Memorandum

To: Ric Weinschenk
CC:
From: Mike Nugent/Manager of Inspection Services
Date: 08/27/2002
Re: 548 Island Ave.

I have done a partial review of the building plans and need the following:

ROOF PLAN

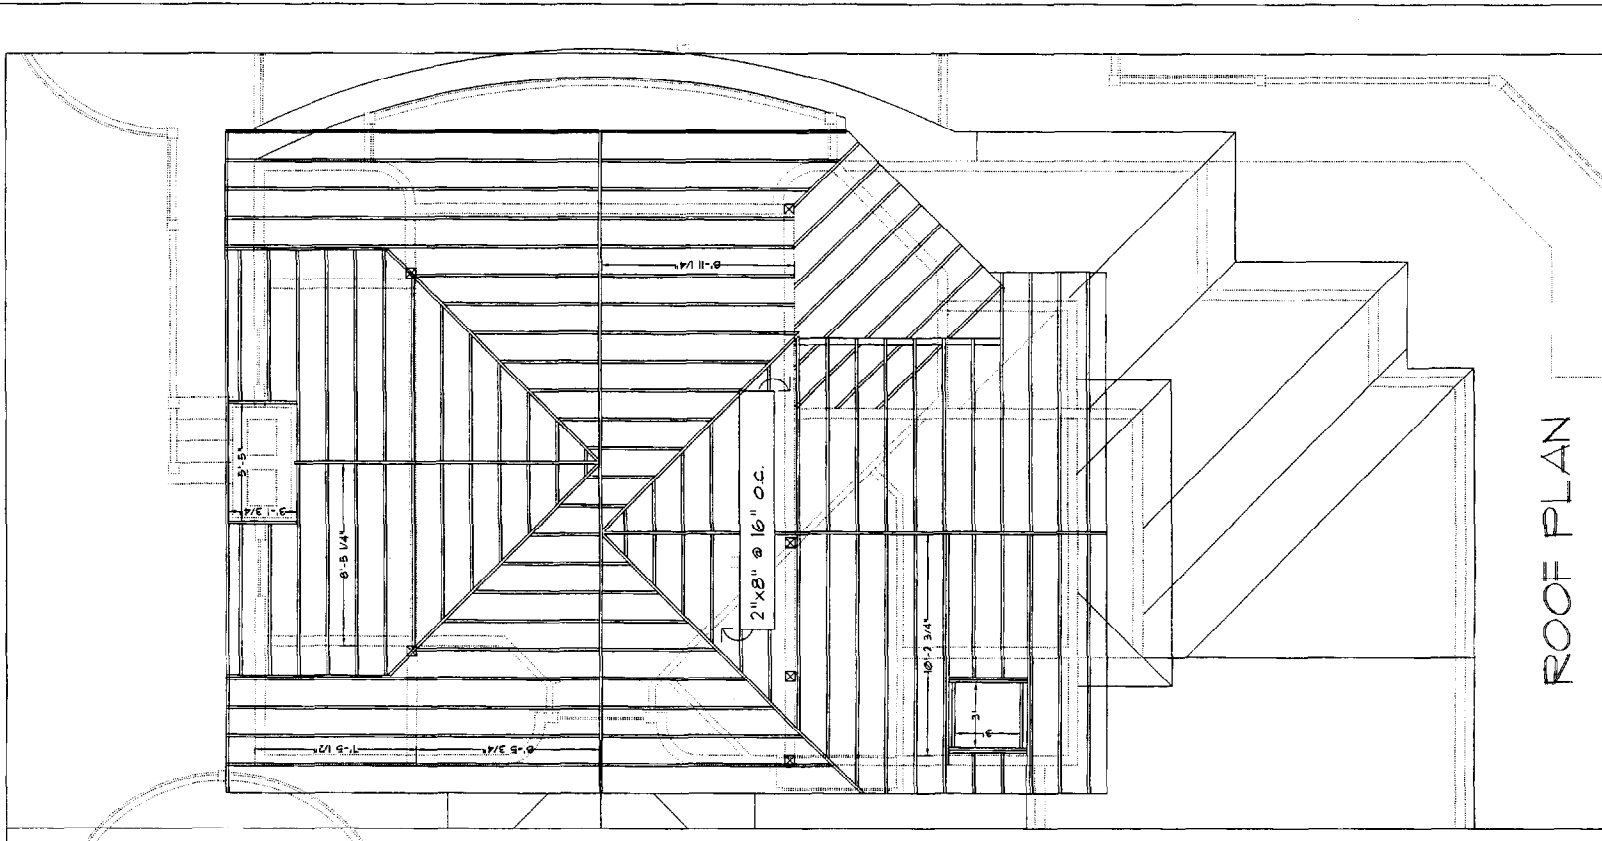
- 8) The roof detail above the lower level is omitted on the roof framing detail ✓
- 9) ½ sheathing---Want kind? *OSB.*
- 10) Floor sheathing not shown. *ADVANTEC.*

UPPER FLOOR FRAME PLAN

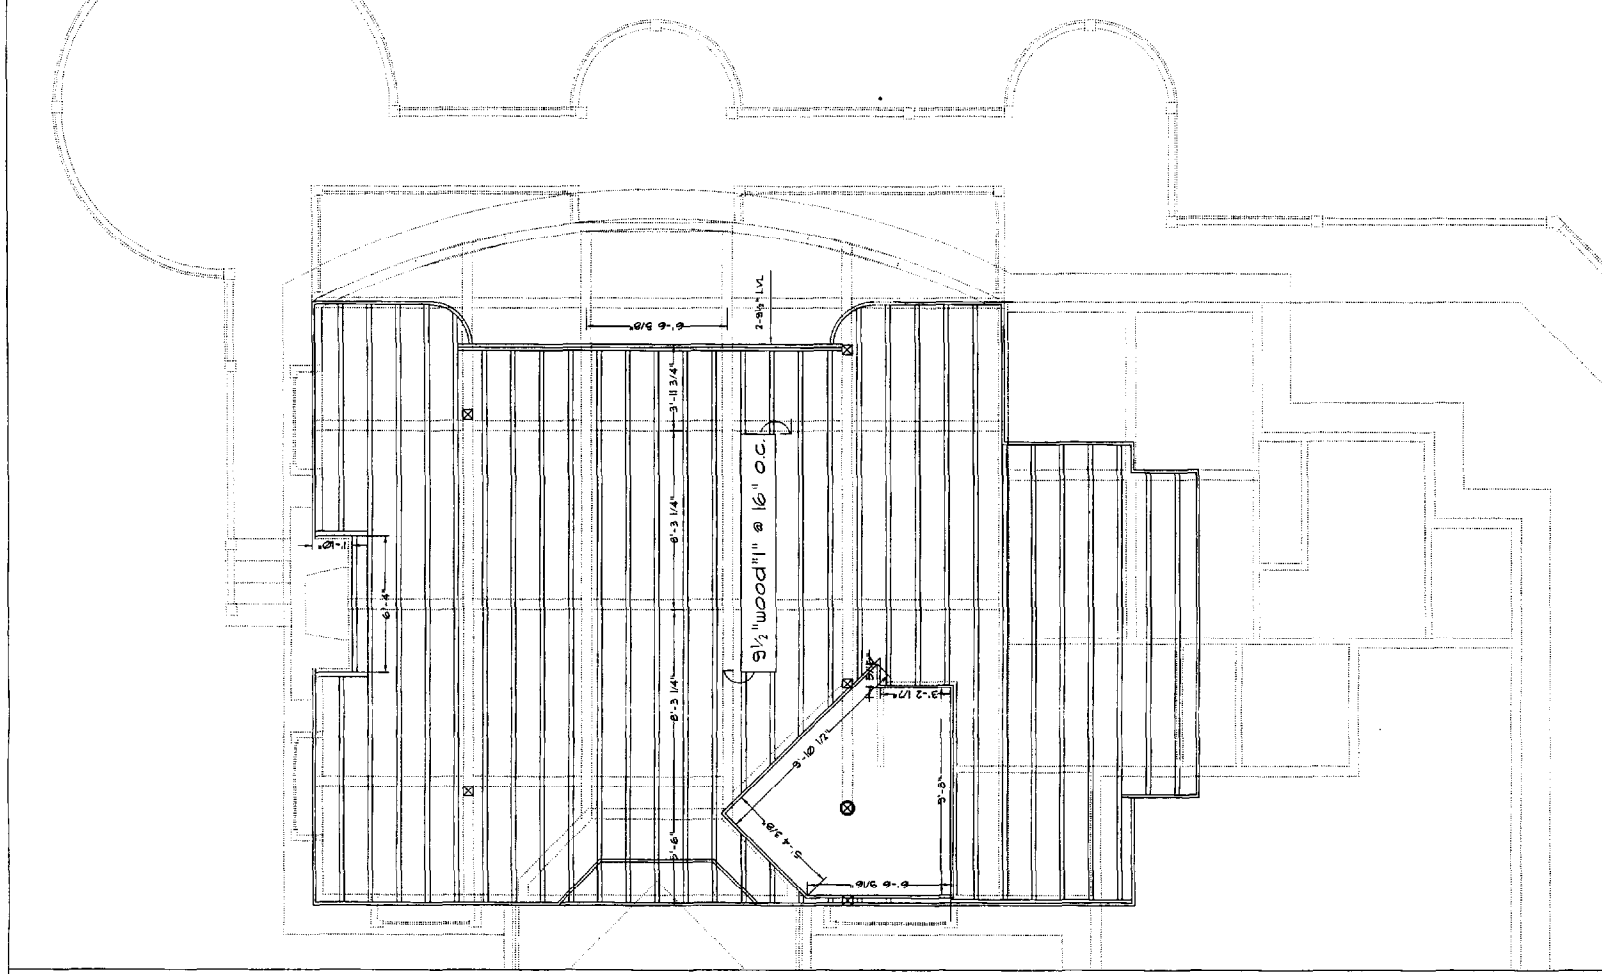
- 6) The Specific brand of "wood I" joists to be used *CD.*
- 7) The Beams in the upper floor system are confusing, do they cross? if so how are they affixed to one another? ✓

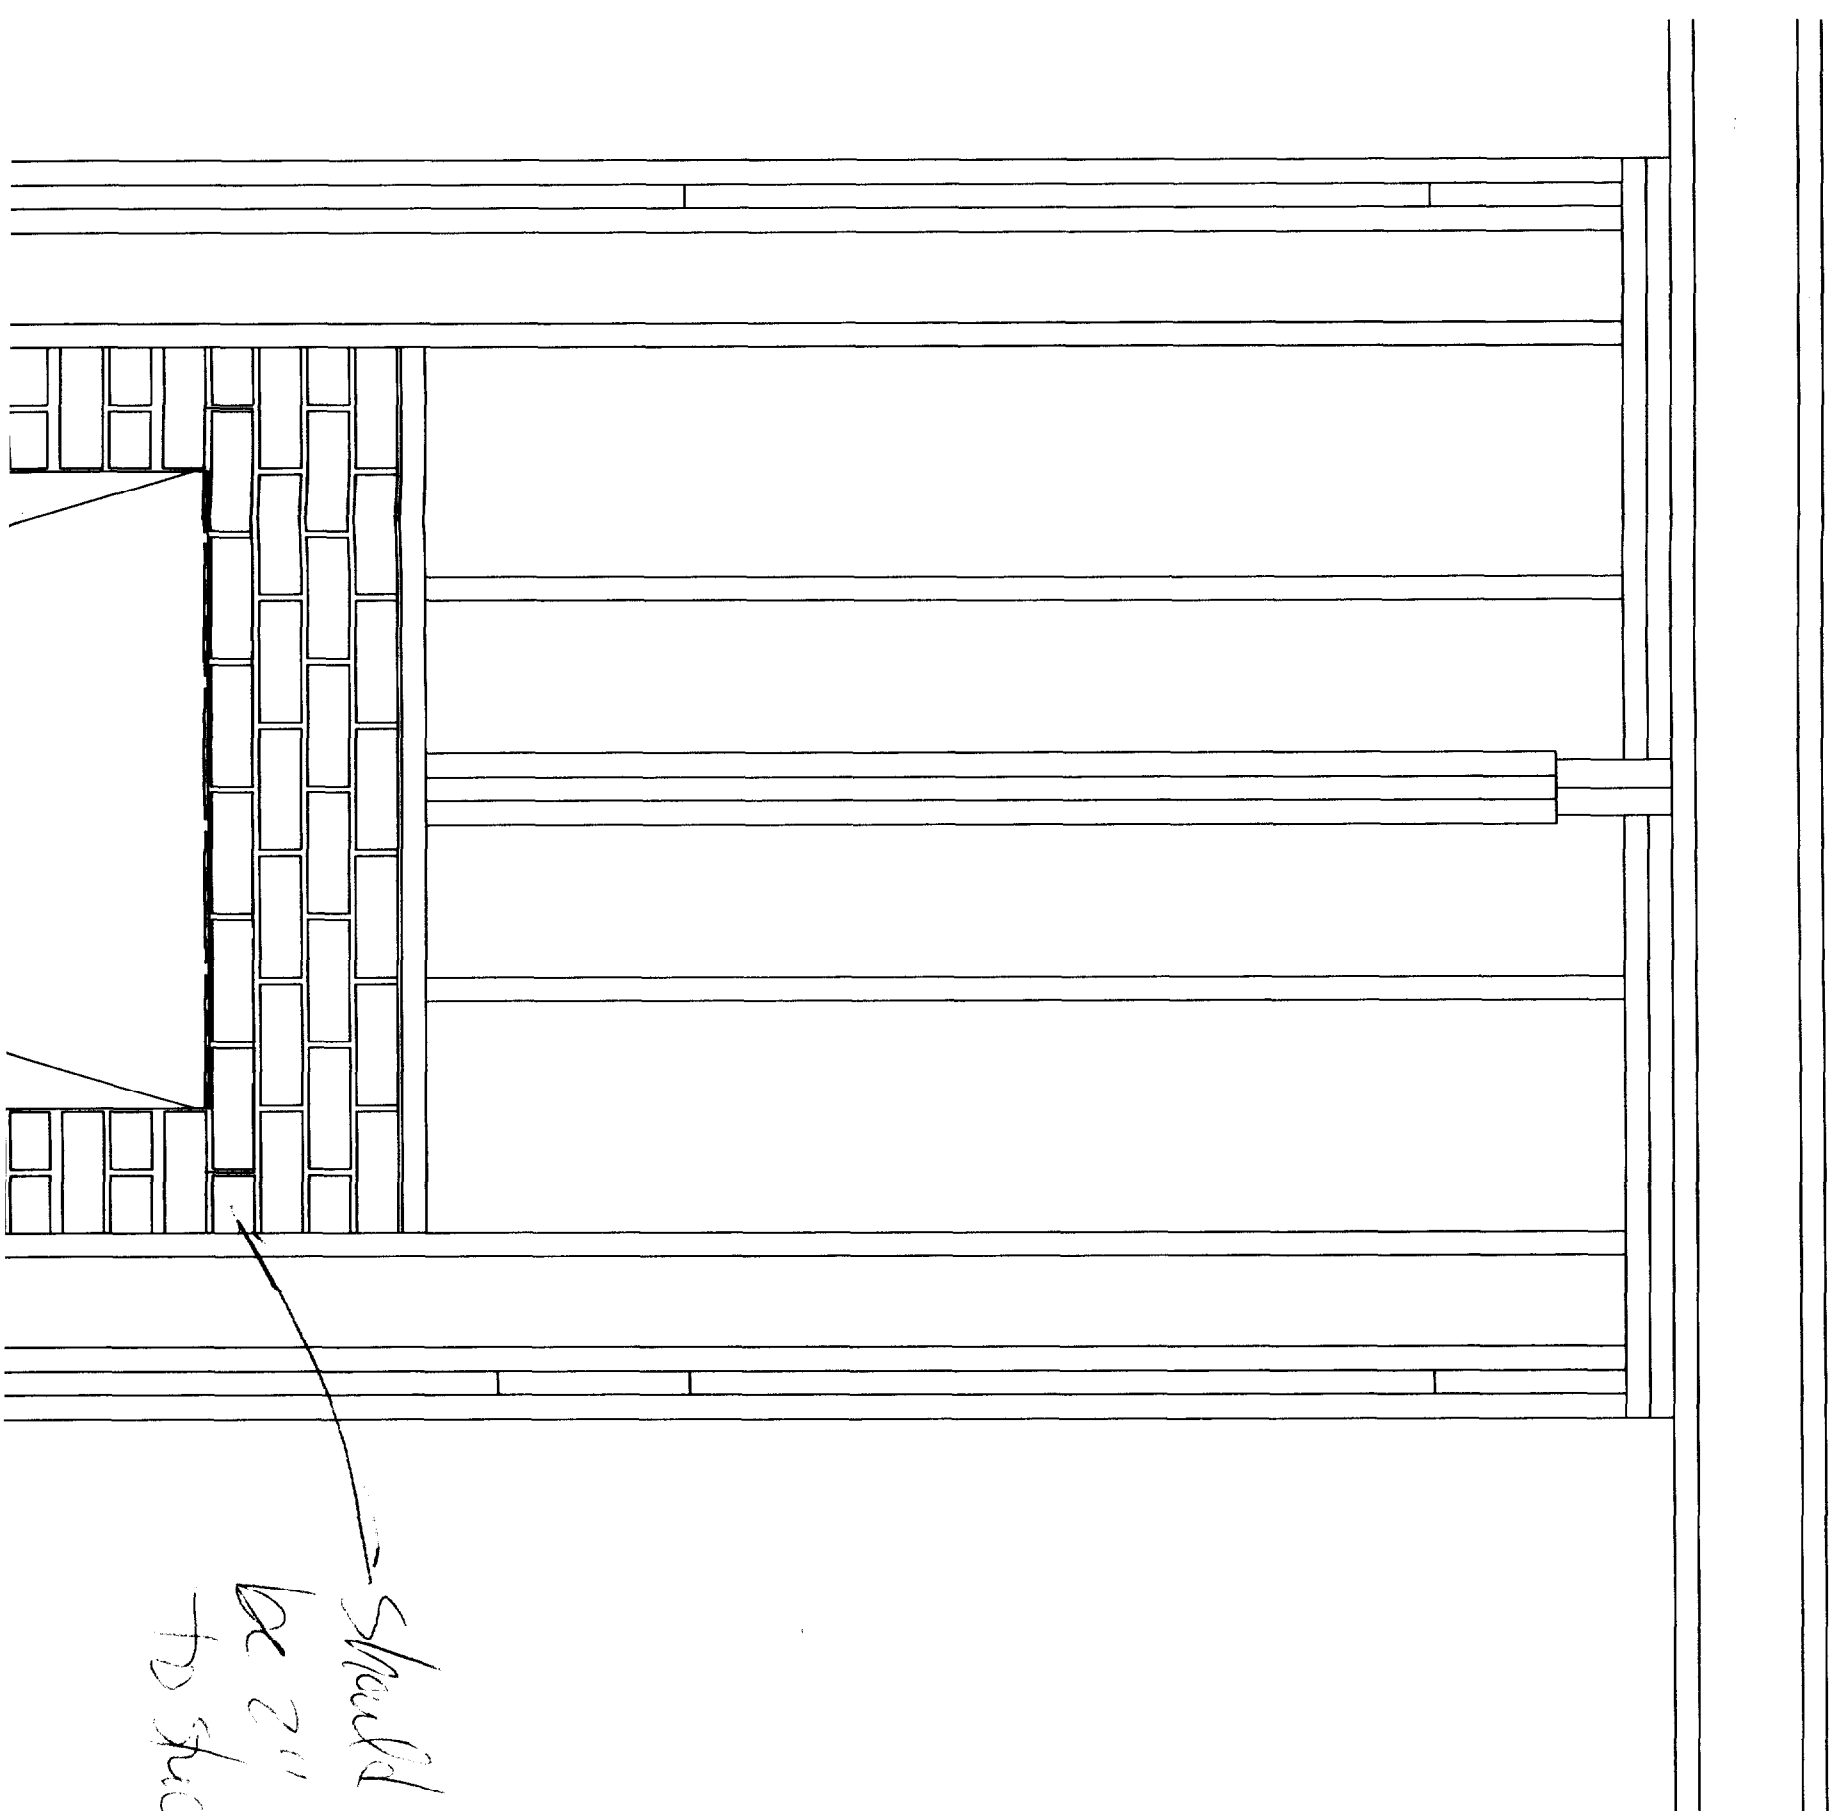
- 16) roof covering not shown *ASPHALT & FELT.*
- 17) attic access not shown ✓
- 18) Need complete rubble stone fire place detail that includes **all** elements construction with dimensions.

BLOW-UP DETAIL
 SCALE 1"=1"

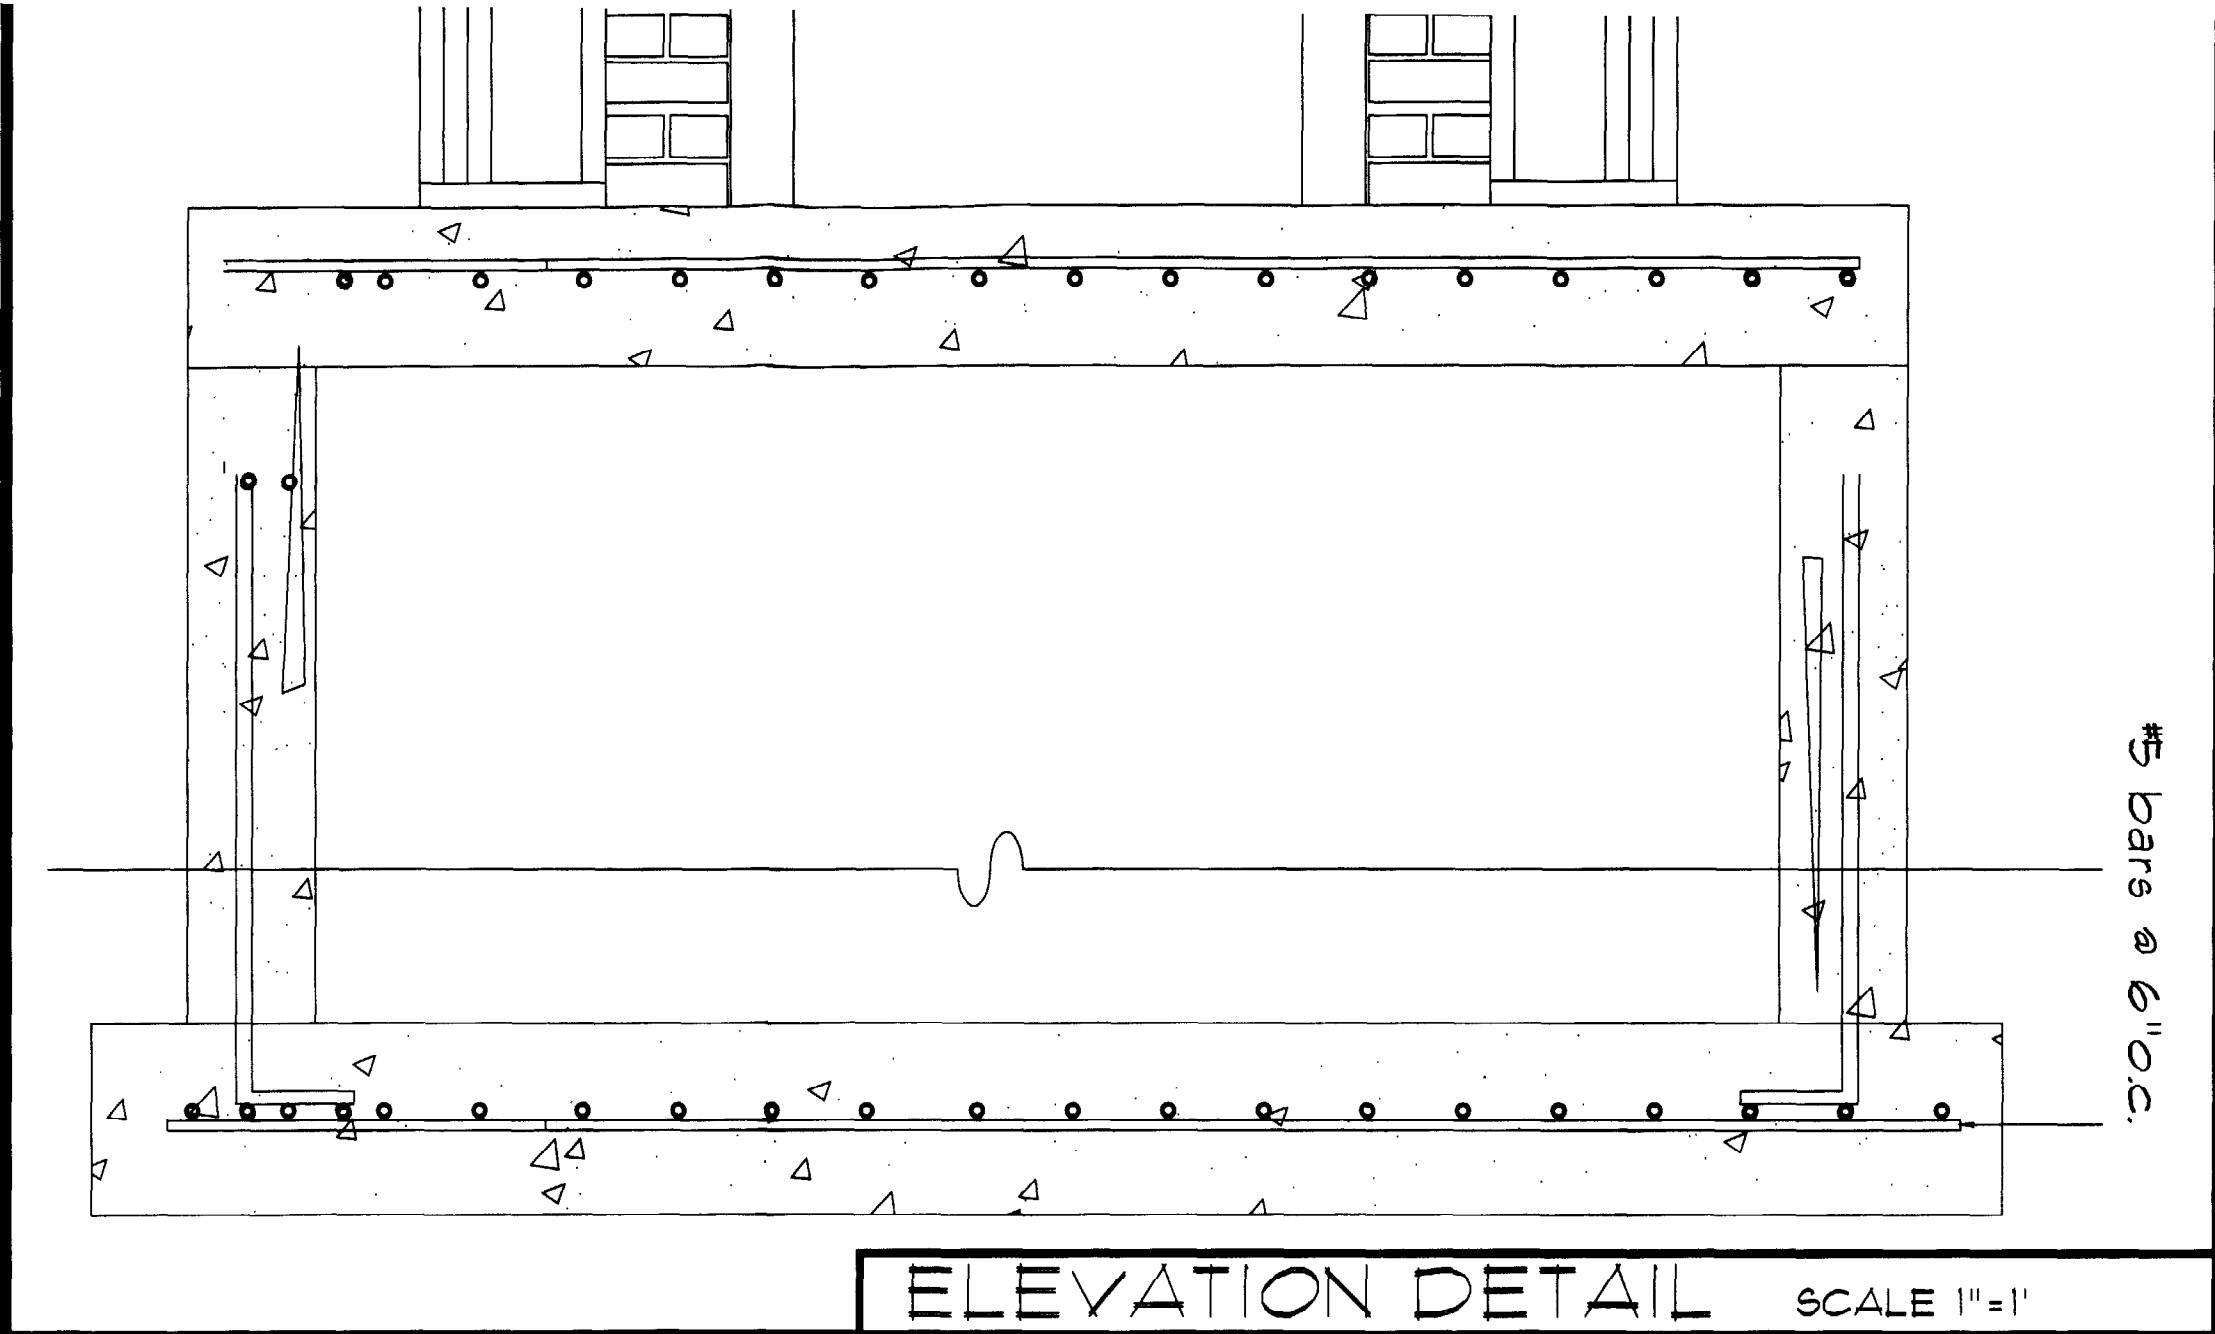
- 1) Details shown need to complete to the extent that building code compliance can be demonstrated. the details shown lack that level of information.
- 2) The 12" x 12" footing detail is confusing, please explain ✓
